APPROVED
 Limited building only review
 Permit holder responsible for
 full compliance with the code

A frame built on stilts
 20x30

sheet no.
S1 of **S1**
plan no.
2312-15

Ron Sherpinkas
274 Valerie Lane

Structural Design By:
John Alexander McRae, PE, Inc
218 Coley Farm Road
Fuquay-Varina North Carolina 27526
jampe@nc.rr.com (919) 210-5749
P O Box 1466 Apex, NC 27502
Report deficiencies immediately
2312-15
(NC C-2298)

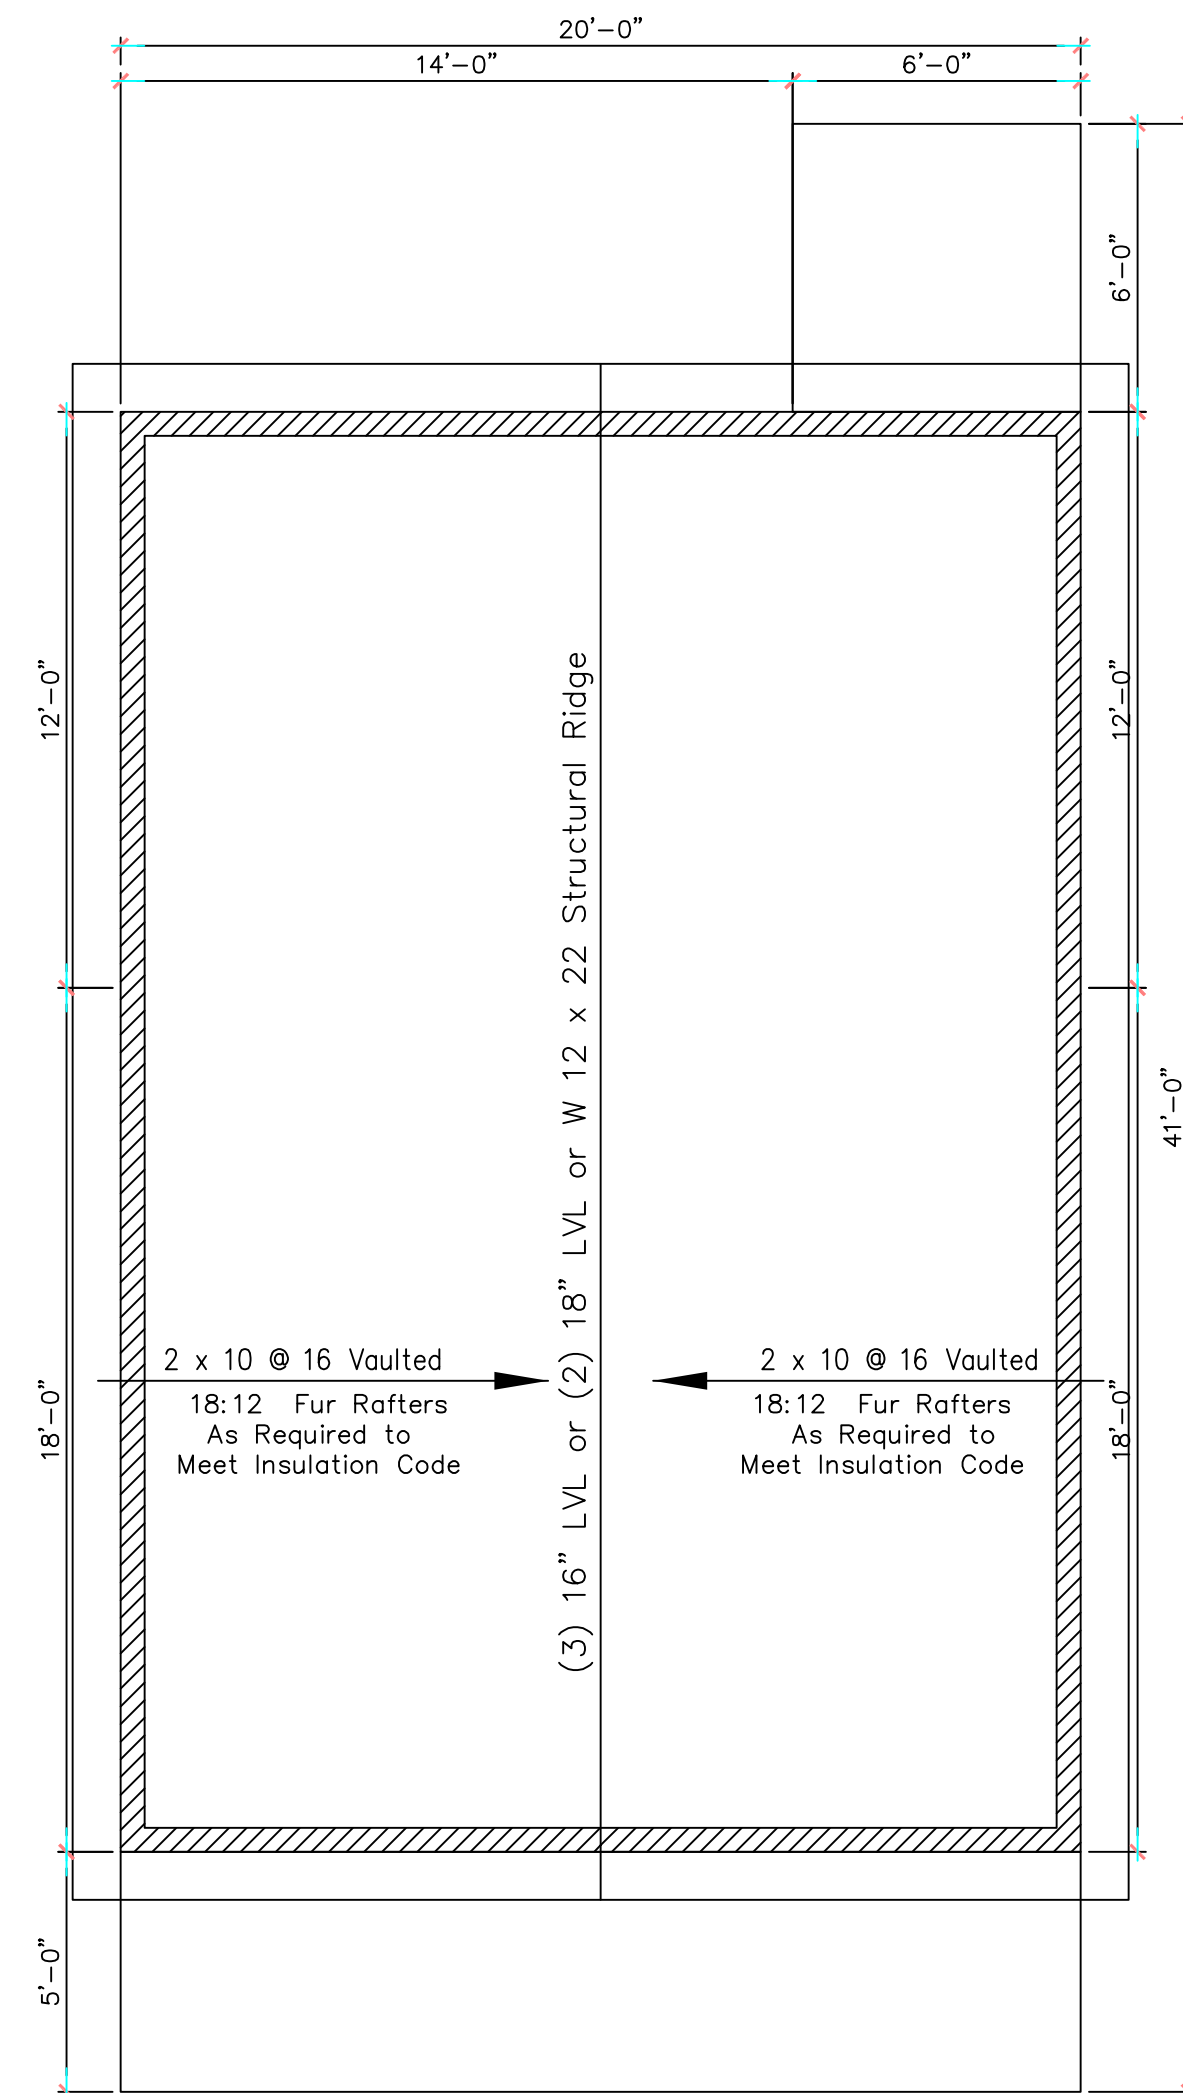
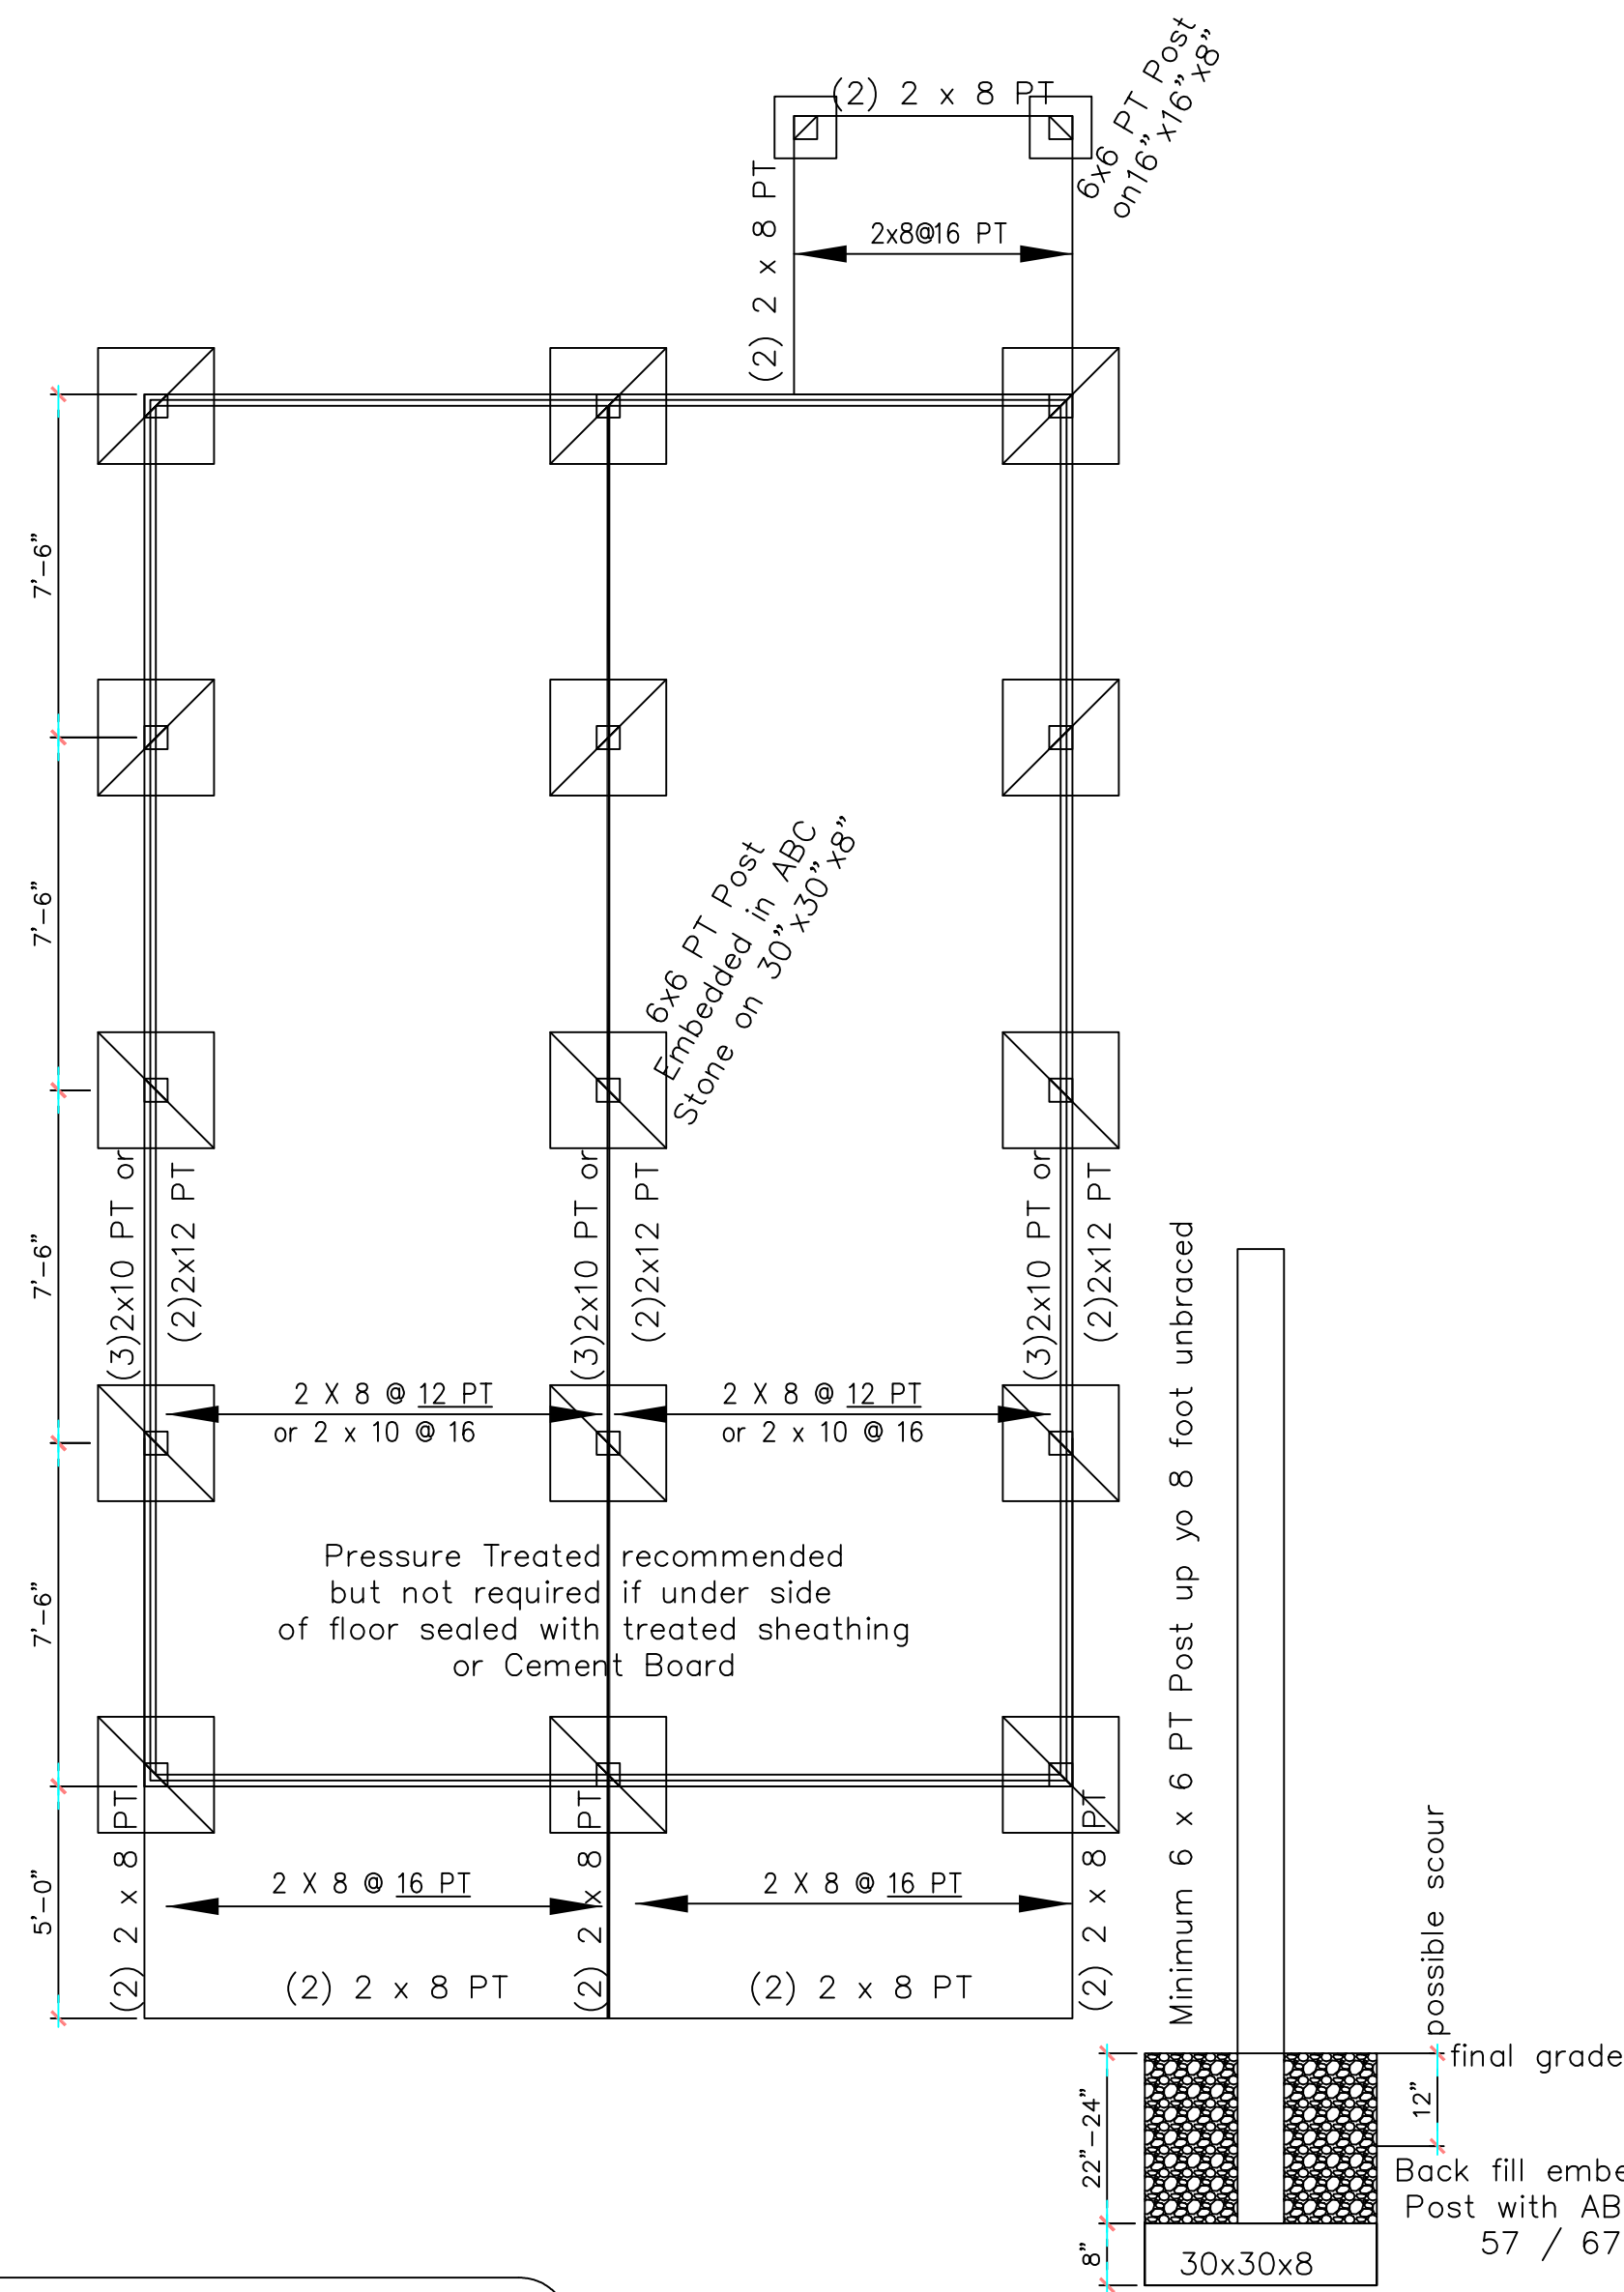
See all notes. Code
 compliant egress window
 required in loft. All egress
 windows shall meet 2nd
 floor requirements
